**Consultation Response from Alan Smith,
KC Waste Strategy (Refuse & Recycling)**

2025/93572 Land South of, Barnsley Road, Upper Cumberworth, Huddersfield, HD8 8NN

Outline application with all matters reserved, bar vehicle access into the site, for erection of up to 123 dwellings with associated works including open space, landscaping, drainage infrastructure.

Responding Ref: WPN 25 054

Layout For Illustration Purpose Only.

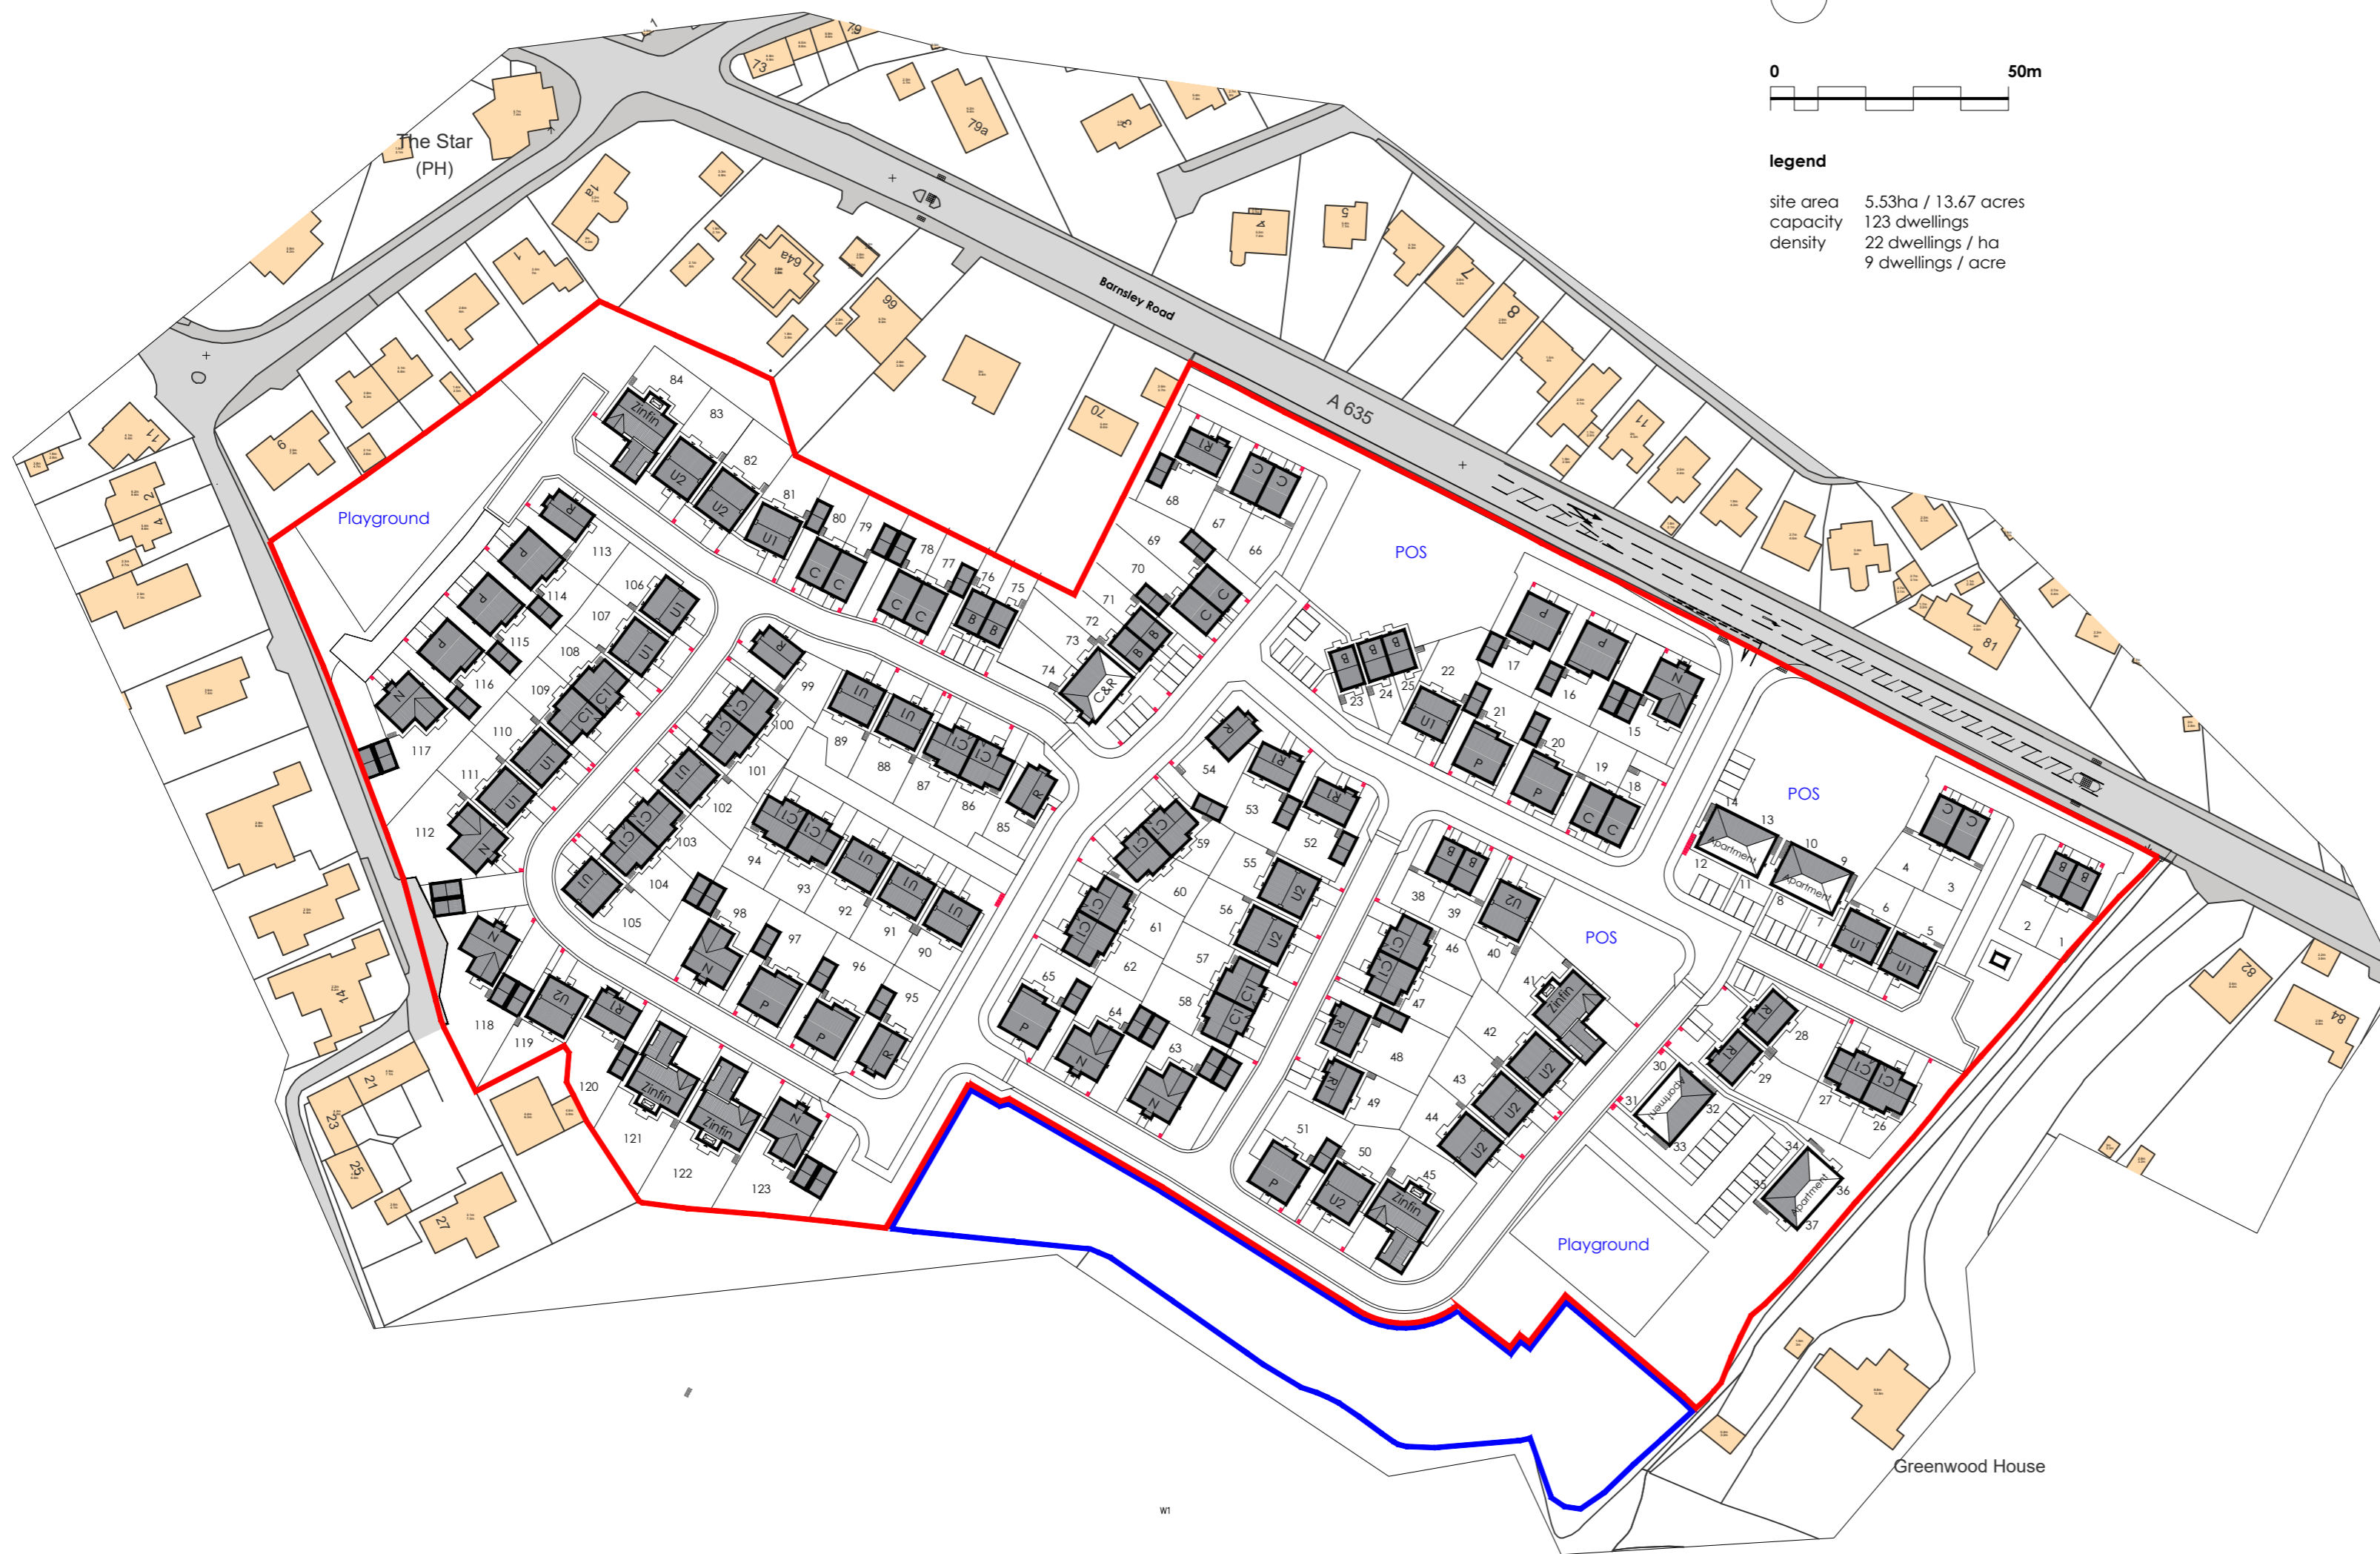
- Must be shown on a layout plan for all properties
- No gradients steeper than 1:12 or steps from storage area to BCP
- Located adjacent to an adoptable highway
- Solid surface required, resistant to constant wear and tear
- The maximum drag out distance from bin storage area to BCP is 25 m (BS5906:2005)
- Temporary BCPs may be needed for early occupiers whilst site is being built (likely collection area would be adjacent to Barnsley Road)

- Site specific comment
 - Plots 1 to 4 will need a BCP adjacent to the adoptable highway outside plot 5. The area must be on hard standing and large enough to hold 4 x 240 L bins.

- Plots 7 to 10 and 11 to 14 will need to show both bin storage areas by an adoptable highway and BCPs. Each block will need a bin store, to screen the bins, that can hold 3 x 1,100 L bins, 1 x recyclable waste, 1 x residual waste and 1 x garden waste or future Simpler Recycling Legislation.

- Plots 30 to 33 and 34 to 37 will need to show both bin storage areas by an adoptable highway and BCPs. Each block will need a bin store, to screen the bins, that can hold 3 x 1,100 L bins, 1 x recyclable waste, 1 x residual waste and 1 x garden waste or future Simpler Recycling Legislation.

- Plots 66 to 68 will need a BCP adjacent to the adoptable highway by plot 69. The area must be on hard standing and large enough to hold 3 x 240 L bins.

- Plots 90 to 94 will need a BCP adjacent to the adoptable highway by plot 90. The area must be on hard standing and large enough to hold 5 x 240 L bins.

- Plots 114 to 117 will need a BCP adjacent to the adoptable highway by plot 113. The area must be on hard standing and large enough to hold 4 x 240L bins.
